Richard Mason

Re: Development Application for 'Mount Errington' 1 Rosemead Rd. Hornsby, Lodged by Best Practice Education Group Ltd.

DA/1119/2019.

Title
SITE AND ROOF PLAN

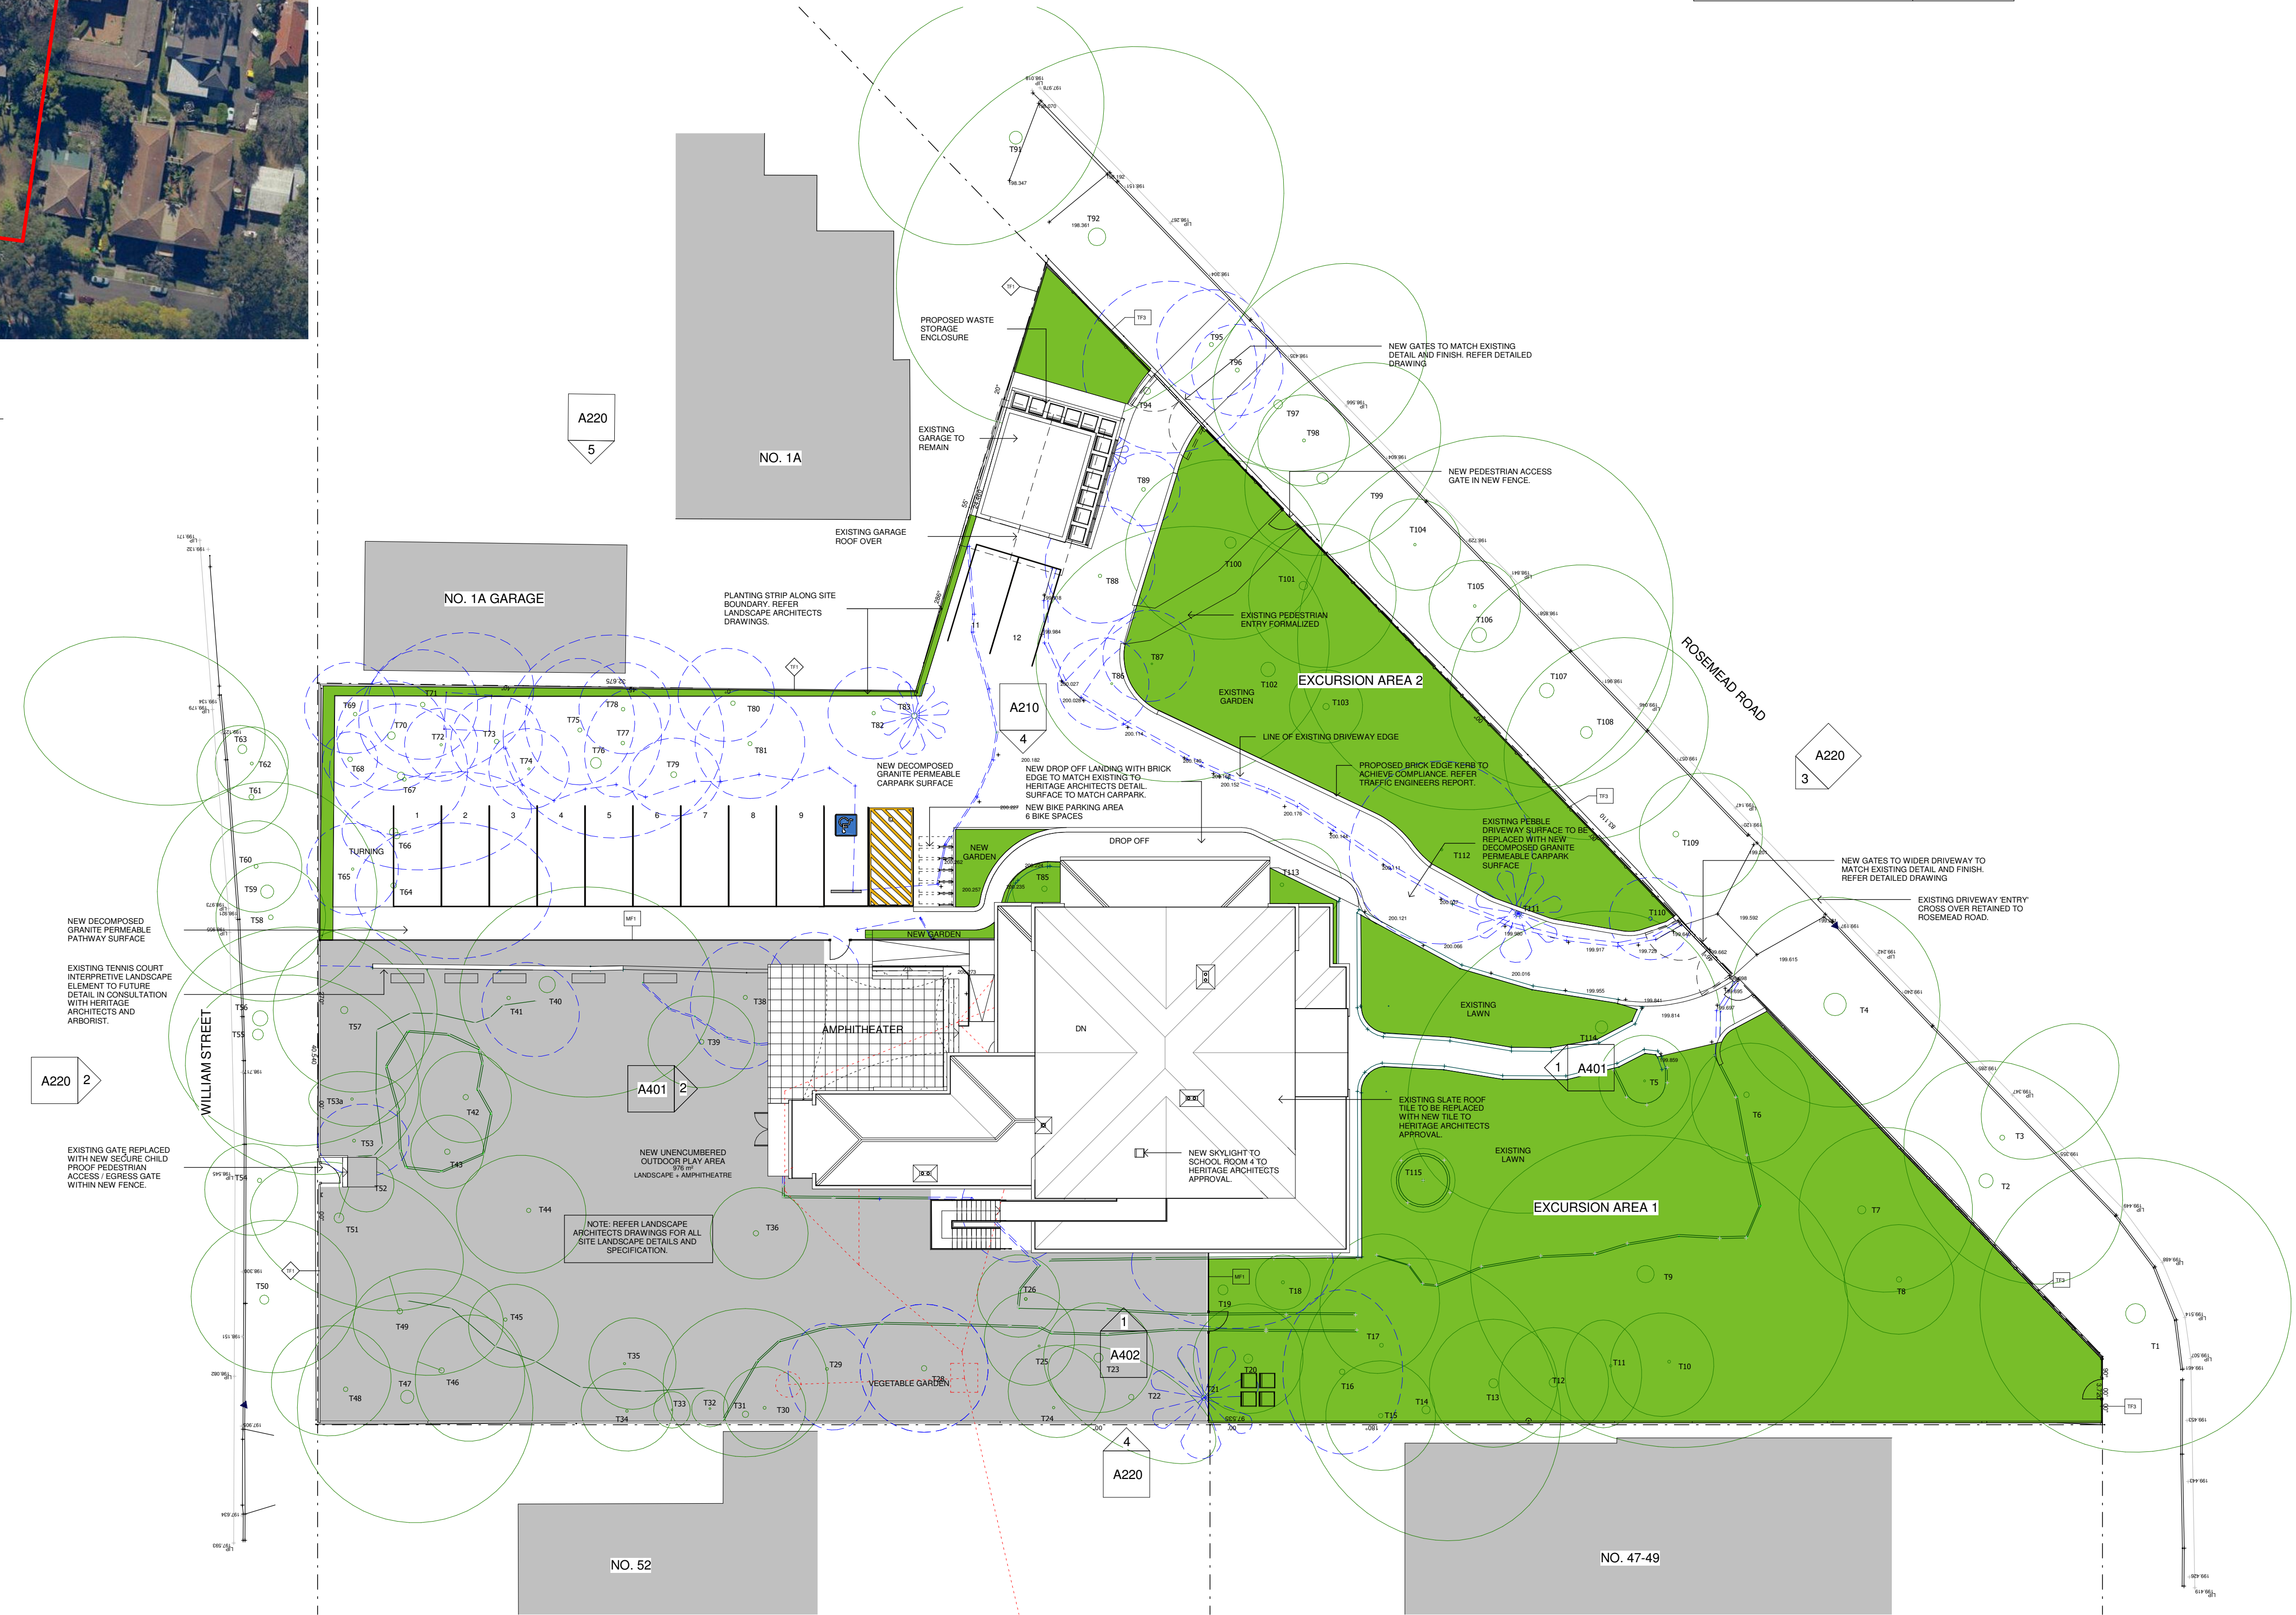
It is proposed to widen some of the internal doorways requiring the removal of the architraves and doors which are to be stored in a safe place in case a future owner should wish to restore the house to its former state. It is also proposed to establish wet areas to be the sites for toilet facilities in two rooms, one in the south-west corner of the house, the other in the back room in the southern wing of the house. This raises again the question of the adequacy of the local water supply. This will entail extensive plumbing in the house and grounds. All these changes will make it virtually impossible for a future owner to restore the house to its former state.

It is further proposed to widen the drive way entailing the removal of the front gates which are to be re-erected somewhere on the block.
